A46 Newark Bypass

Statement of Common Ground with Historic England

**The A46 Newark Bypass
Development Consent Order 202[#]**

**Statement Of Common Ground with
Historic England**

Drawing file: TR010065 / TR010065-000155-TR010065_A46 Newark Bypass_6.2 Figure 2.3 Environmental Masterplan.pdf

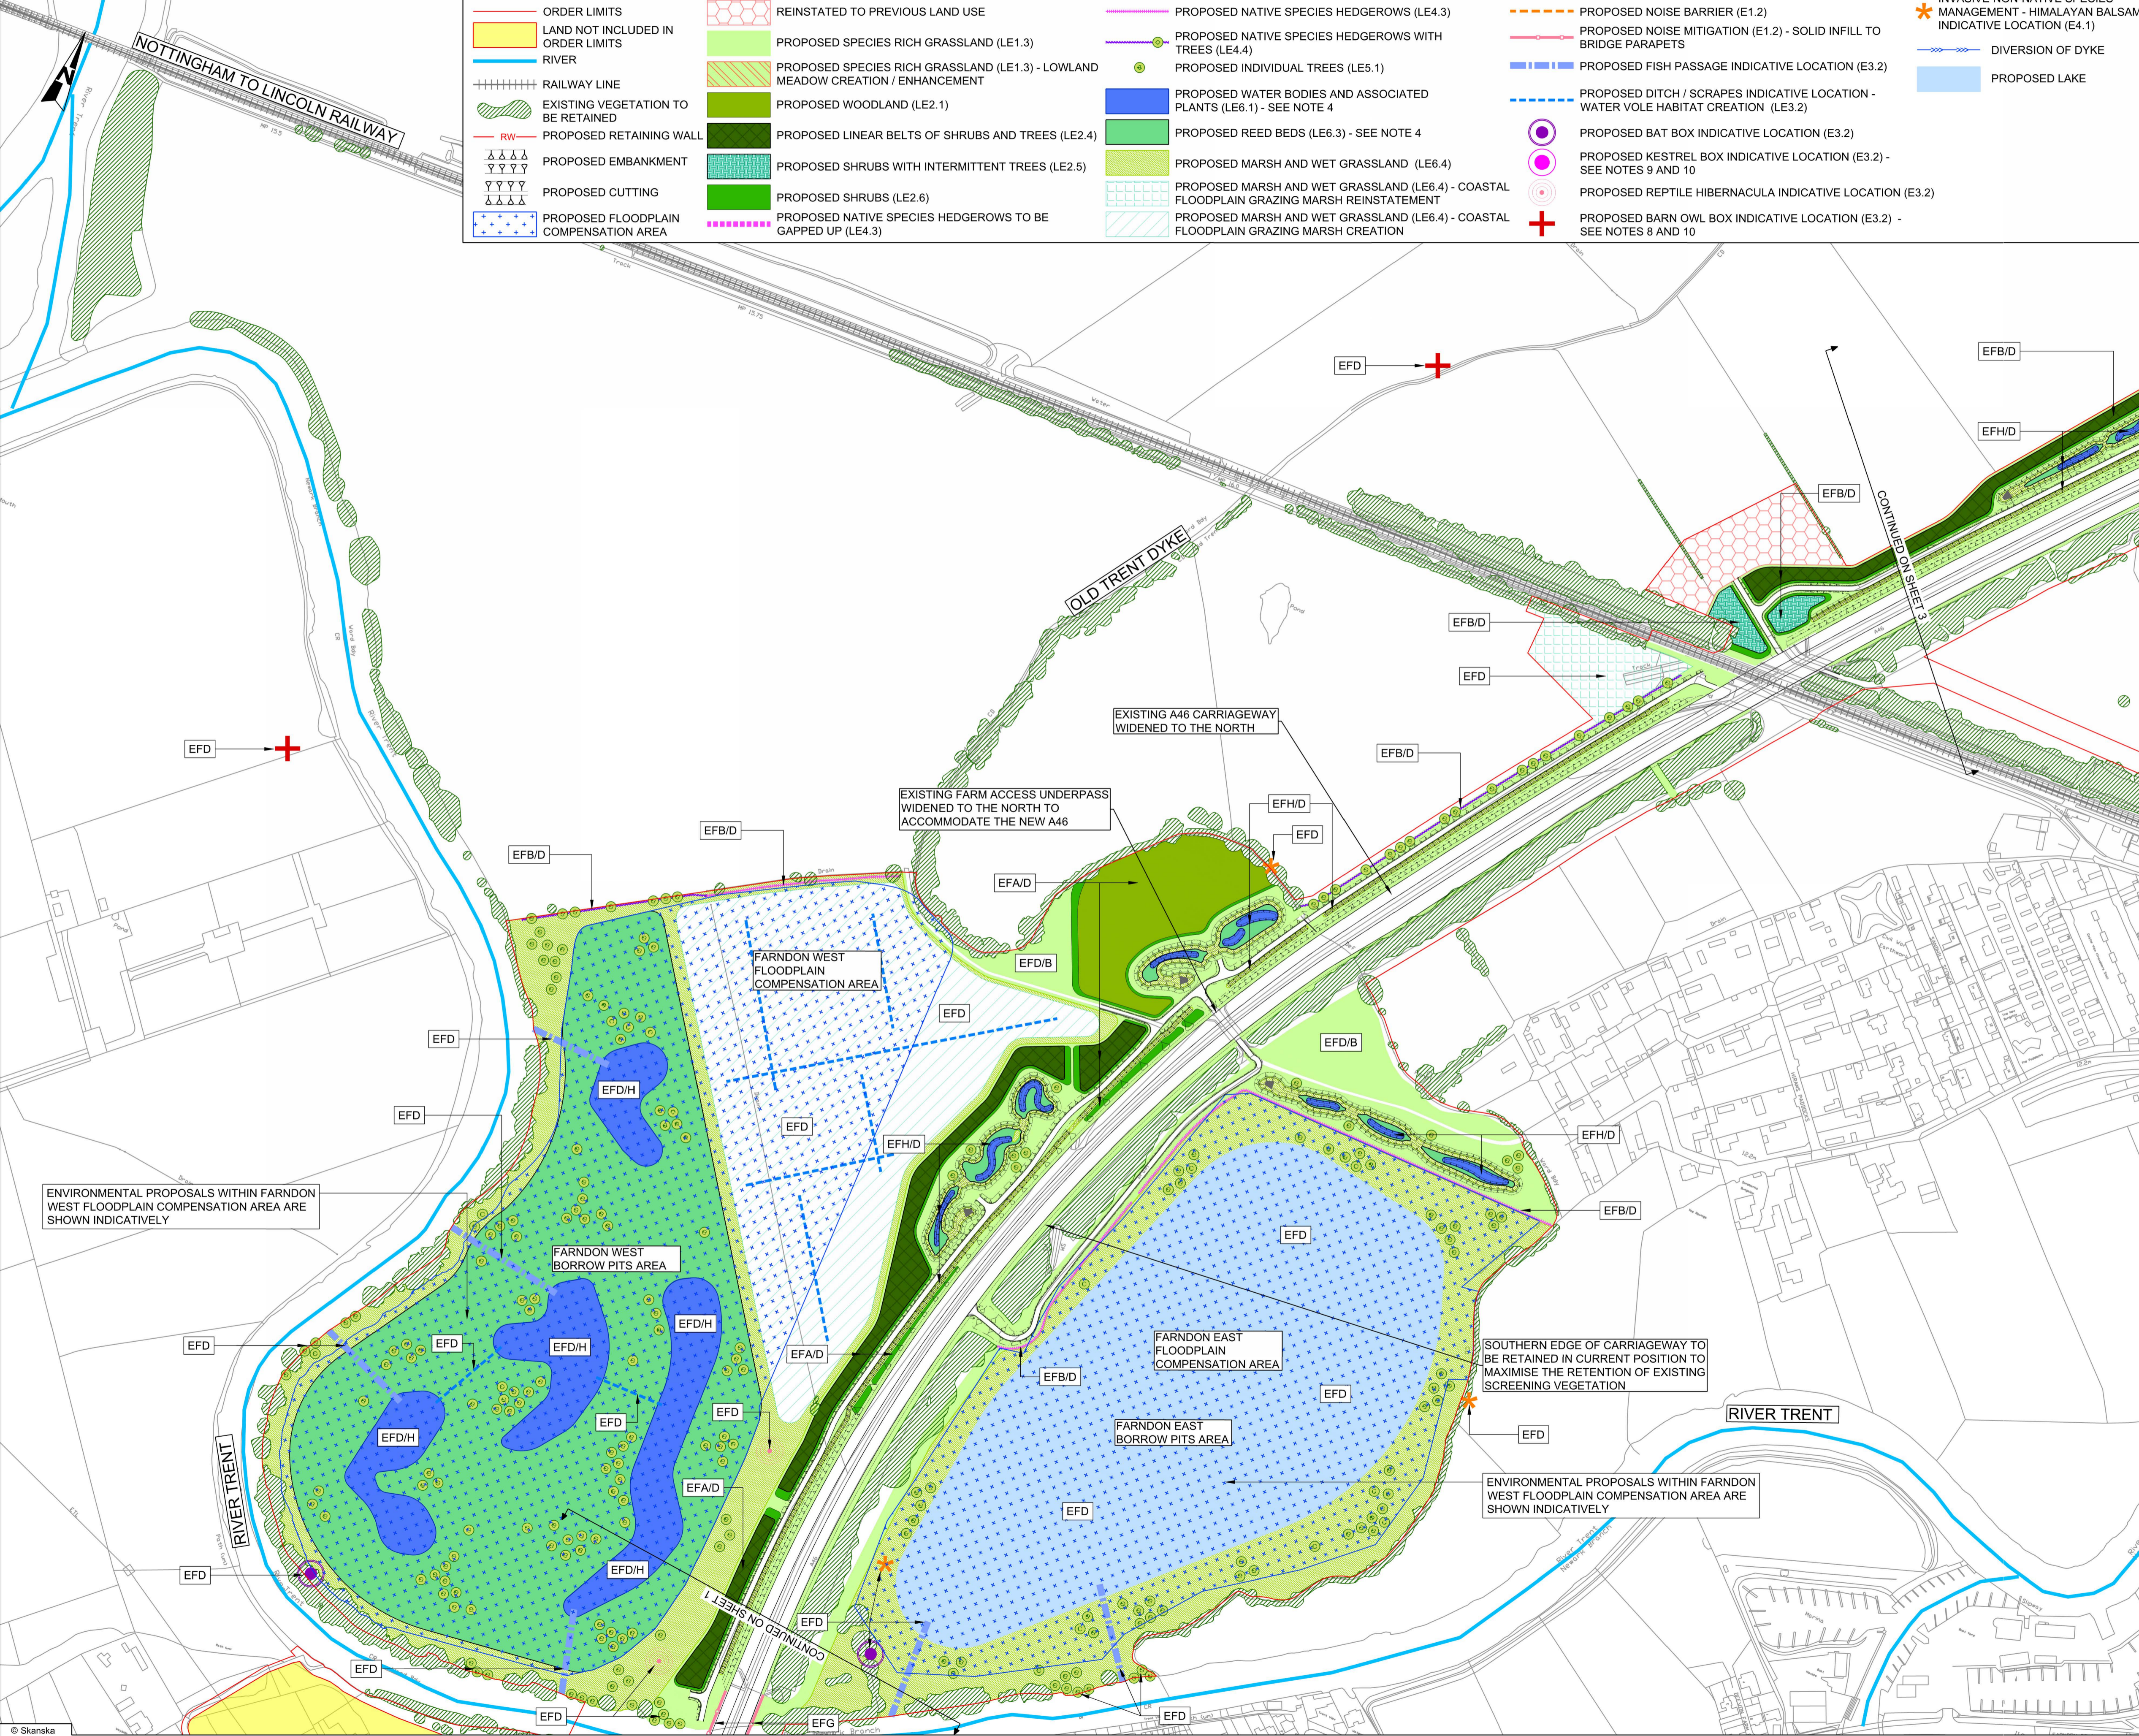
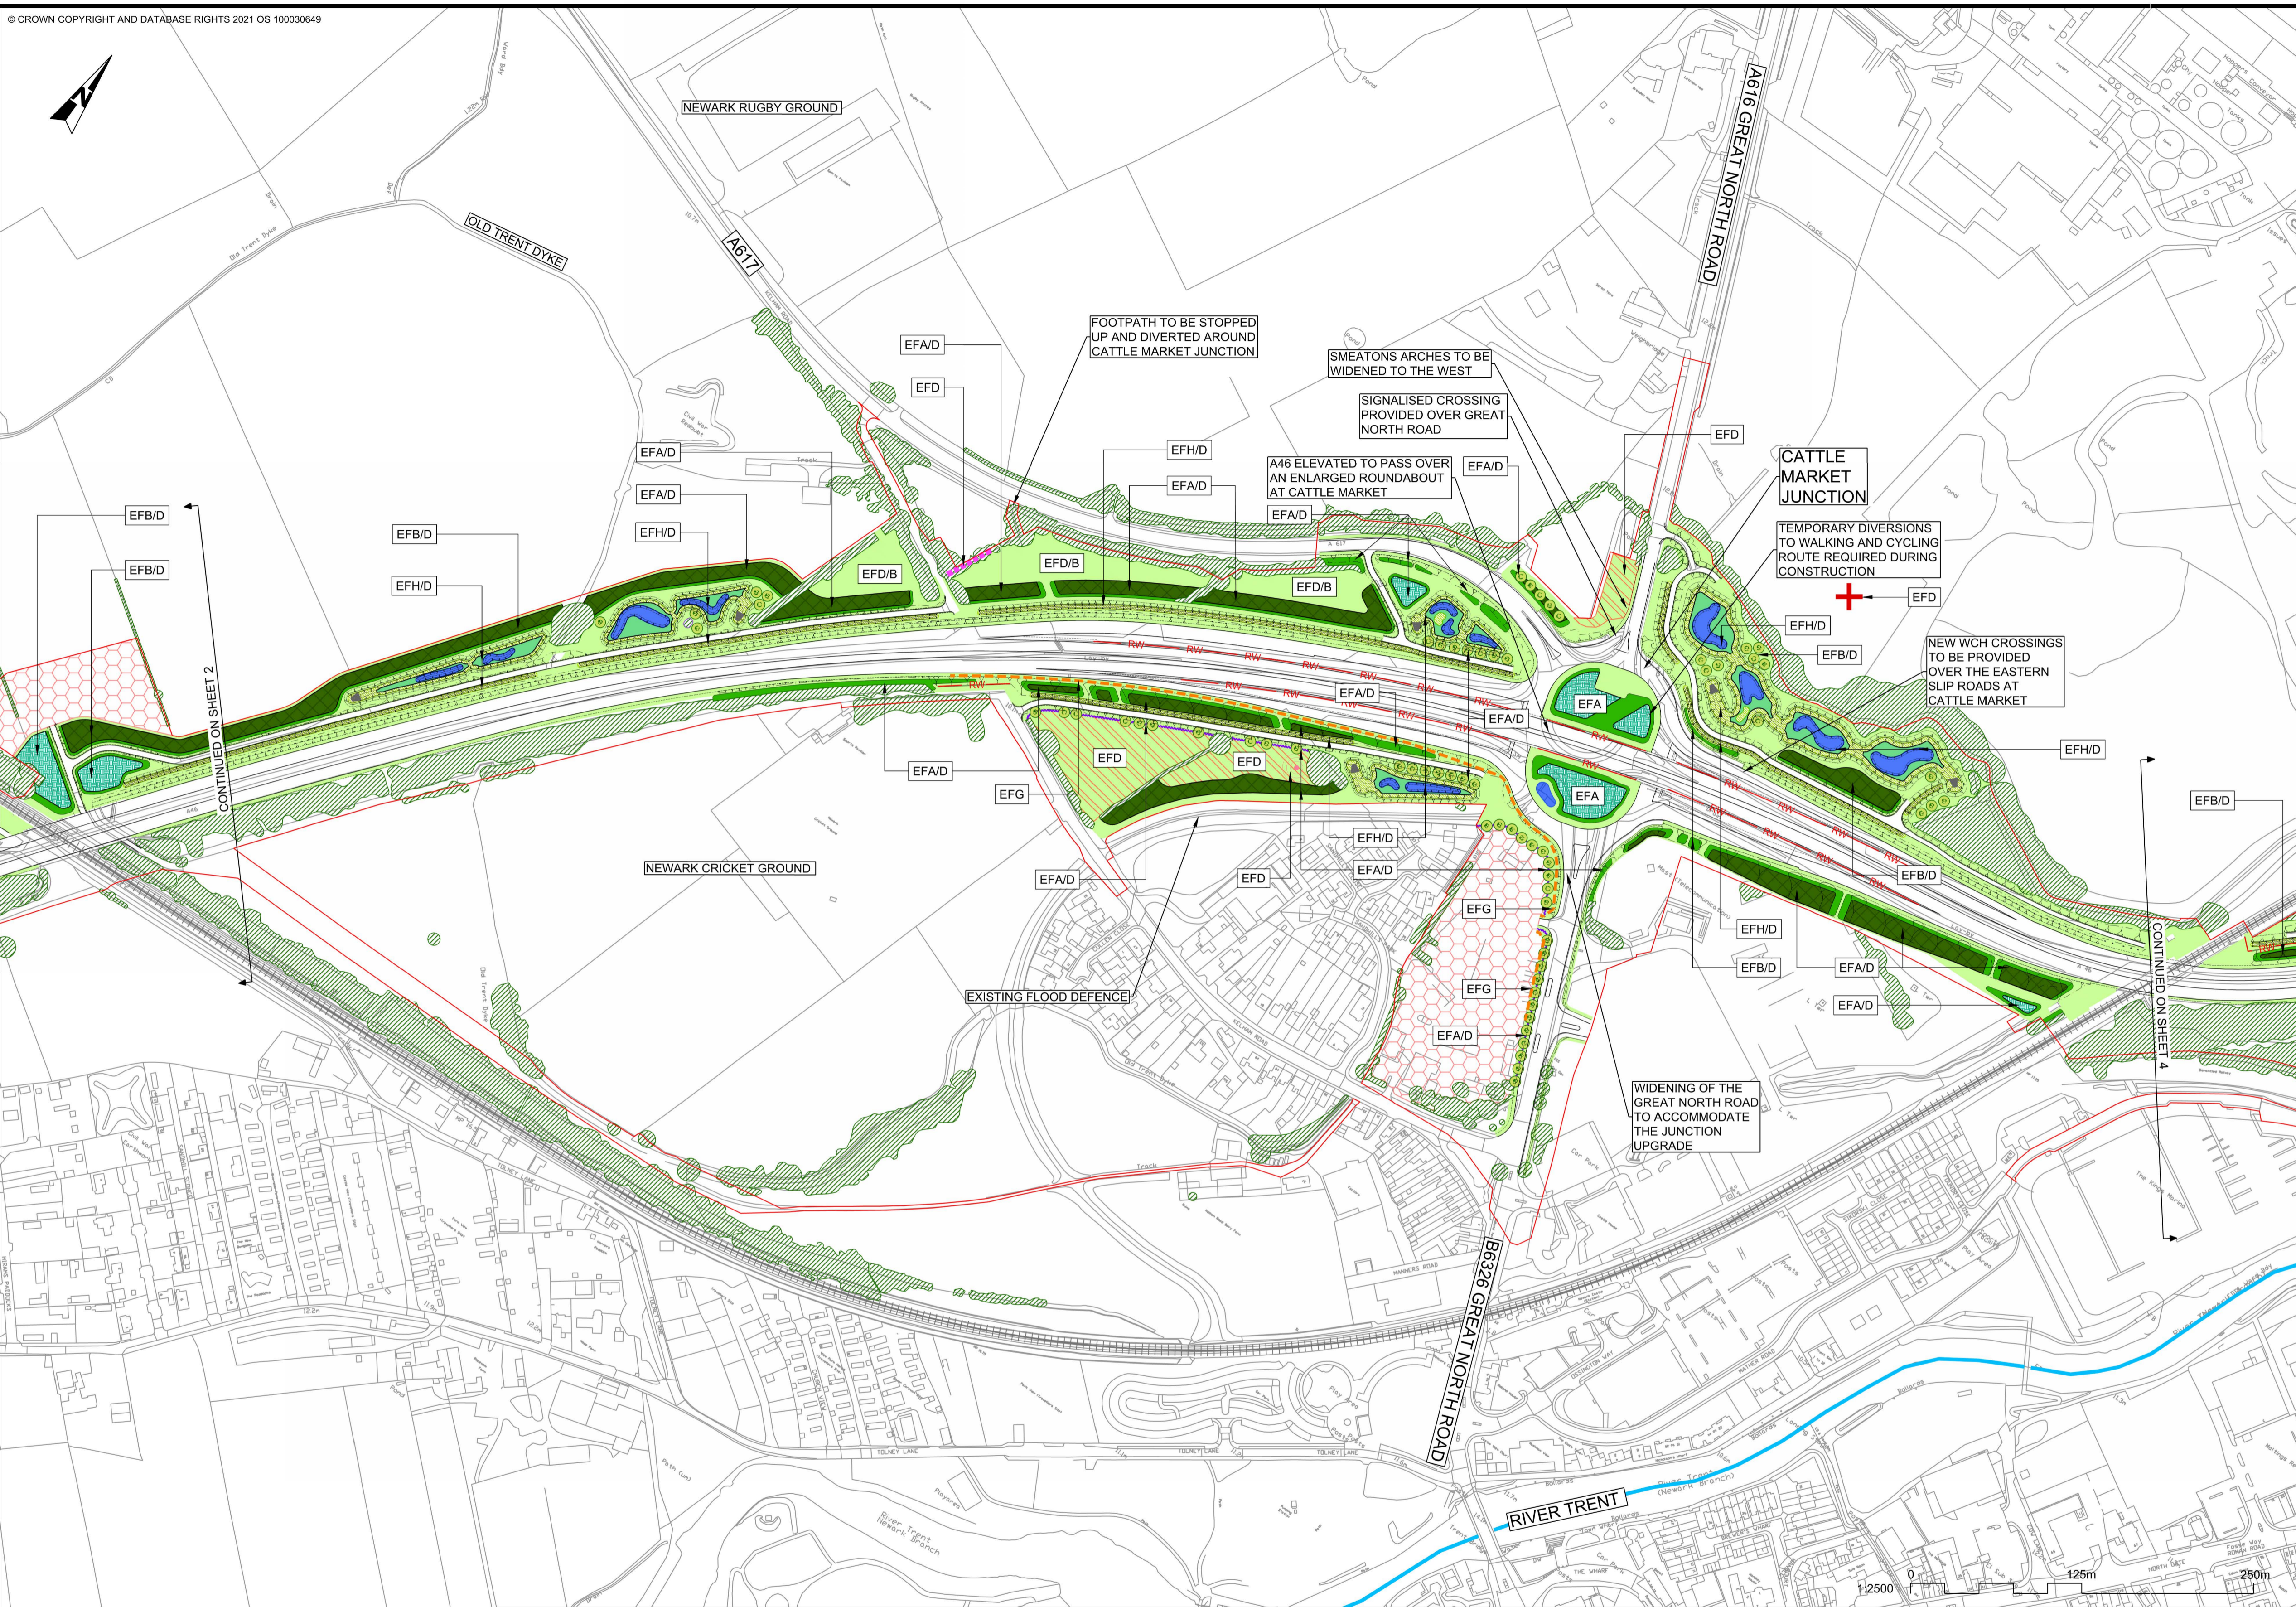
13.	Langford Hall – new approach road and entrance gates	Figure 2.3 (Environmental Masterplan) of the Environmental Statement Figures [AS-026]	<p>Meeting with Historic England 11/10/2024:</p> <p>Understand rationale behind linear route for new driveway between new proposed entrance and location where it meets the existing driveway. This route avoids historic copse of trees at original end of the driveway. The direct line approach meets the existing driveway at a natural break in the trees.</p> <p>Agree that there is no clear rationale, or extra benefit to creating a faux curvilinear approach in this location.</p> <p>Agree that meeting the existing driveway at the proposed location, ensures that the gradual 'reveal' of the main house is retained and conserved.</p> <p>Discussed requirement for new entrance to 'speak to' the architecture of the Langford Hall, and to serve its purpose of ensuring visitors and passers-by that this an entrance to an important property.</p> <p>Also discussed the importance of the design of any gates, piers, railings, to be a 'foretaste' of the architectural style of the main house – not detailed as a pastiche of work elsewhere, but – appropriate in scale, neo-classical proportion and design, of good quality, natural materials, including brick, stone, lime mortar, estate railings etc, matching the pallet of the house to ensure quality of finished design, and its execution by an appropriately skilled specialist (sub) contractor.</p>	<p>Routes to the north of the proposed landscape bund in order to join at location of lodge were considered but had no clear rationale and would result in impacts to habitats through destruction of a historic copse of trees.</p> <p>Proposed linear route from existing field gate, directly to natural break in historic tree-line is a clear choice, and ensures sense of reveal and arrival afforded by existing driveway is retained and maintained.</p> <p>Proposed new driveway will have avenue tree planting, in line with existing parkland/estate entrance characteristics, as outlined in Figure 2.3 (Environmental Masterplan) of the Environmental Statement Figures [AS-026].</p> <p>The Applicant agrees with Historic England's position with regards to design and detailing pillars/gates/railings for the entrance.</p>	Agreed	11/10/2024

Regarding the detail drawings / materials for the new gateposts and drive at Langford, [REDACTED] please may you get in touch with [REDACTED] on this once the detail is available, to ensure the proposals match the discussions with [REDACTED] on 11/10/24 (see Row 13 of the SOCG).
